JohnsonMowat
Planning & Development Consultants

Our ref.
Your ref. 2025/0121

**RESERVED MATTERS PLANNING APPLICATION REF. 2025/0121
SUBMISSION OF REVISED MATERIAL**

Schedule of Plans/Documents hereby submitted and superseded

Unit 7 Elevations

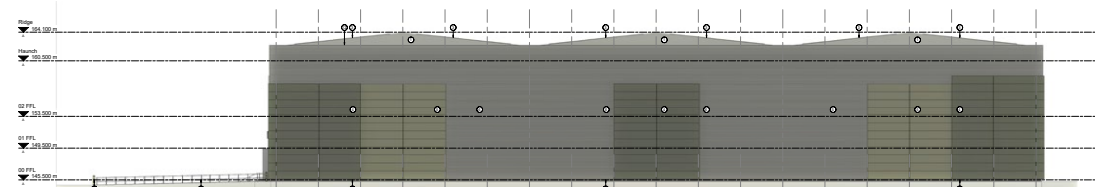
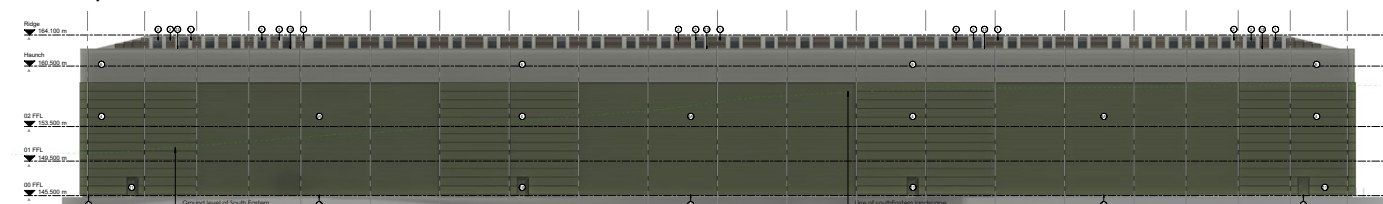
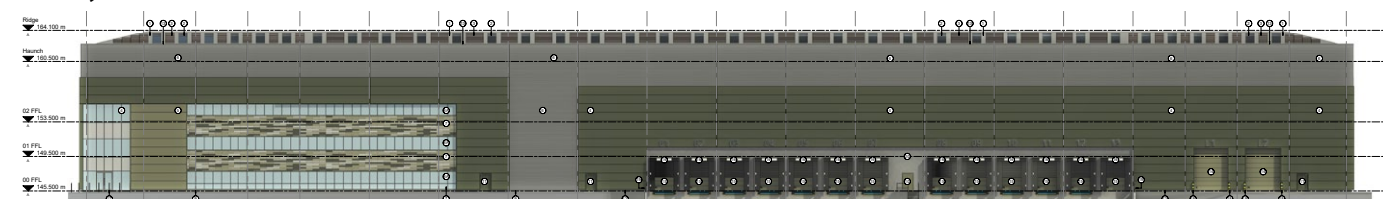
<u>Landscape bund / planting</u> – Visual softening effect of landscaping reduced if planted beneath the plateau level.	Development Proposal
	<u>Building appearance</u> – cladding colour concern / inconsistent with colour palette in Hoyland North Masterplan Framework.	Development Proposal
	<u>Relationship with adjacent housing allocation site</u> – No comfort that building will not affect the setting of future residential development at site HS64.	Landscape / Visual / Setting
Conservation officer	<u>Impact on setting of heritage assets</u> – Concerned over the increase in massing and scale. Cumulative increase adverse impact on setting and how viewed against landscape backdrop. Amounts to ‘less than substantial harm’	Landscape / Visual / Setting
	<u>Landscape / visual</u> – Indicates significant change at some receptor locations. Suggests reducing height to make visual mass less dominating; and change to colours/ cladding to reduce apparent sense of large looming unit.	Landscape / Visual / Setting

The comments on cladding colour are incorrect as the proposed colours are consistent with the colour palette outlined in the Hoyland North Masterplan Framework and with the reserved matters approvals for other plots at the site.

However, the comment may have resulted from a 'drafting error' relating to the colour indicated within the drawings. We therefore submit a set of revised elevation drawings, 3D image and Design and Access Statement with the colours addressed.
